Berrima Hotel State Significant Development (SSD-66876472)

I object to the proposed redevelopment of the former Berrima Gaol by Bluesox as described in the company's EIS placed on public exhibition until 26 November 2025, for the following reasons.

1 West Elevation_Wingecarribee River
1:250

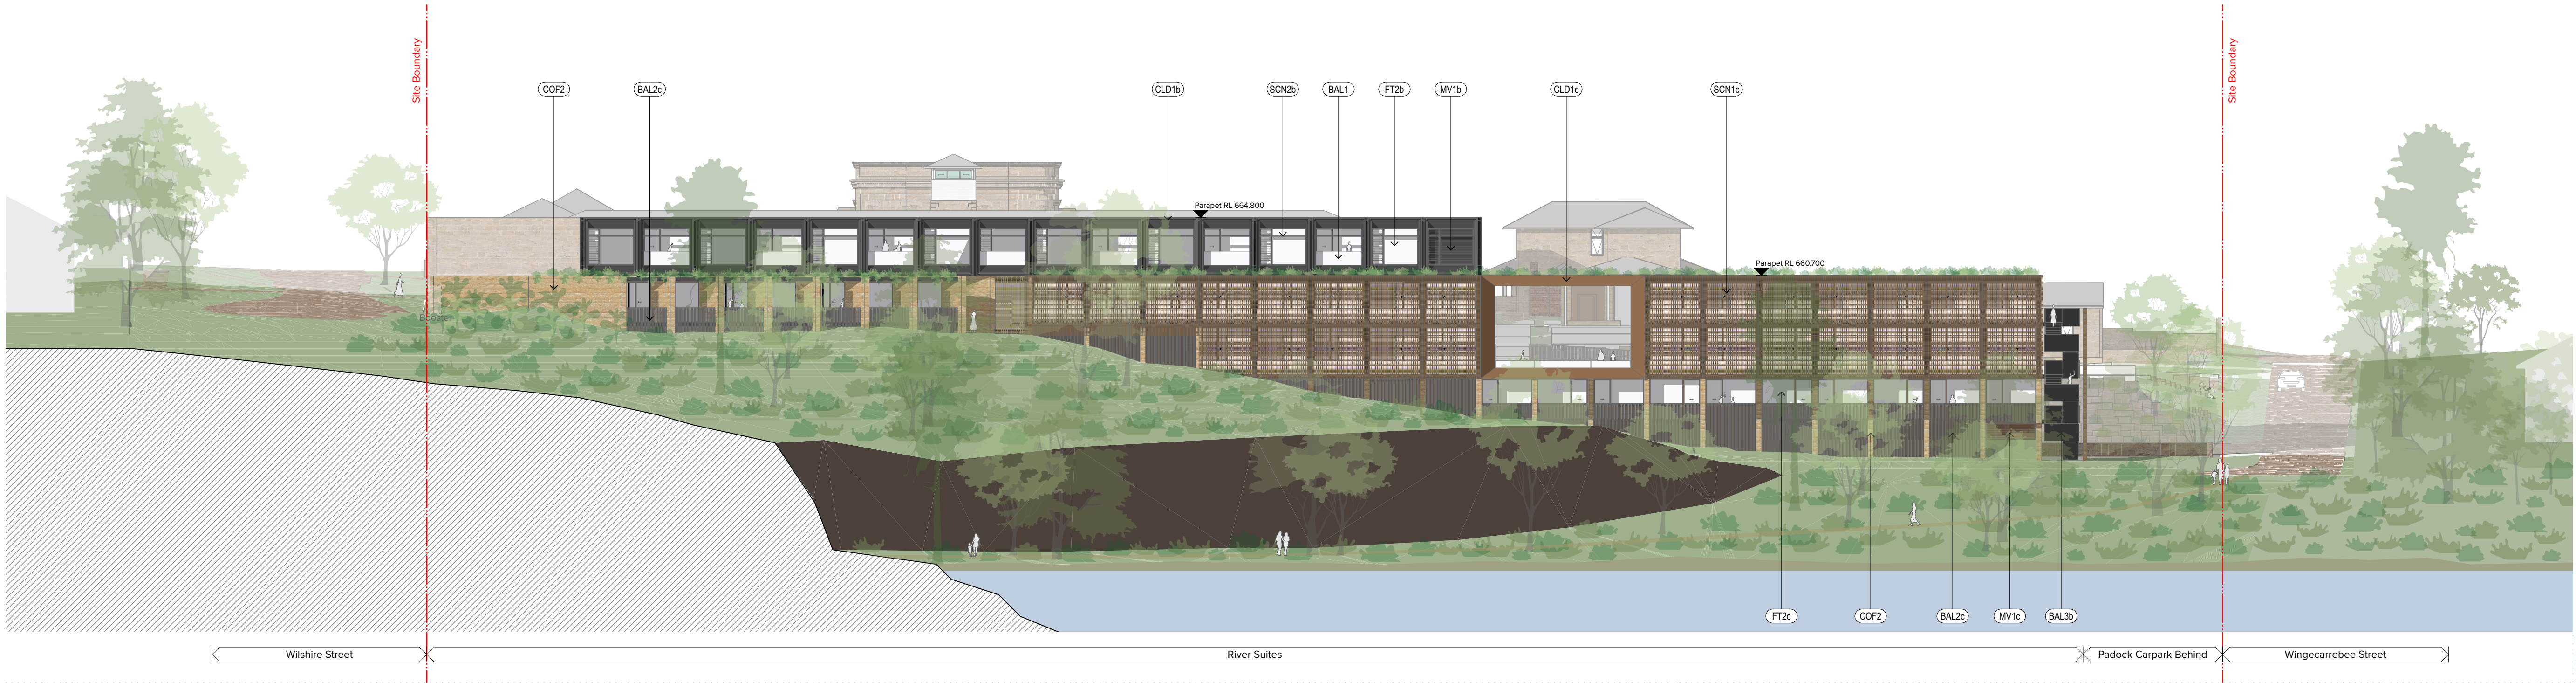
The western wall of the Gaol is obscured by the "massed bulk" accommodation building (Appendix 23, Western Elevation). (Appendix 5B Western Elevation. This option compromises the curtilage of the Gaol and obliterates the important views of the Gaol from the western side of the River and Lambie's Well walk.
